## MEMORANDUM

**DATE:** October 14, 1996

**RE:** Request for Certificate of Occupancy  
101 Country Lane(lot 6)

LOT 6 PHEASANT HILL (101 COUNTRY LANE)
ANASTOS + LOHNES LLC
MENARIO RESIDENCE

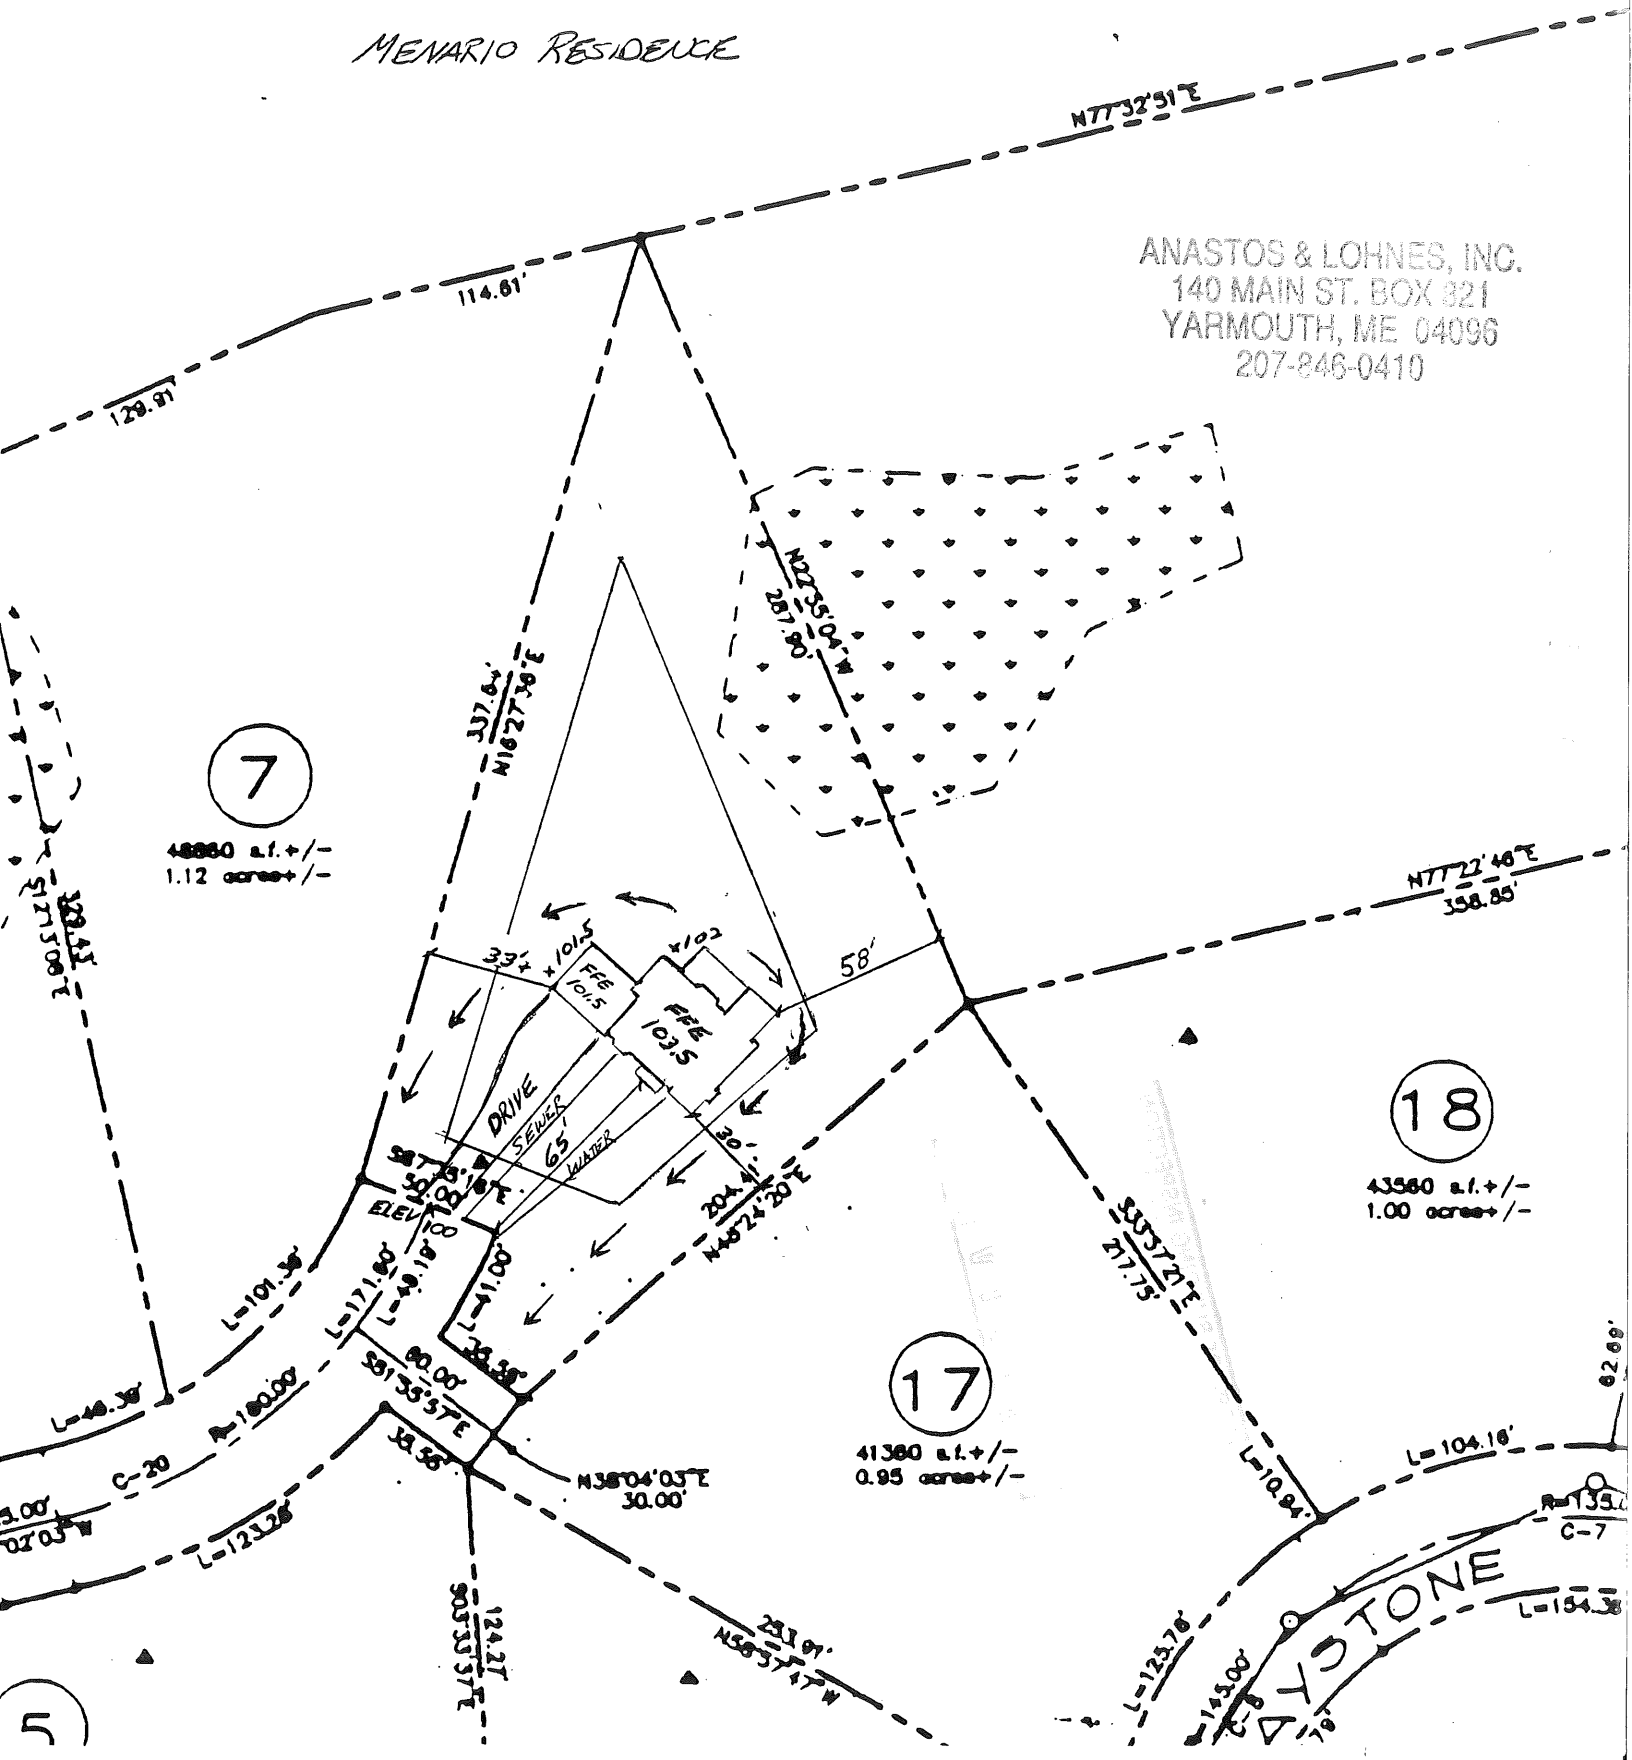
1. Resubmit the site plan that shows the location of the foundation drain as required in condition 14.
4. Confirmation from Public Works that as-built data for the sewer and stormwater services has been submitted.
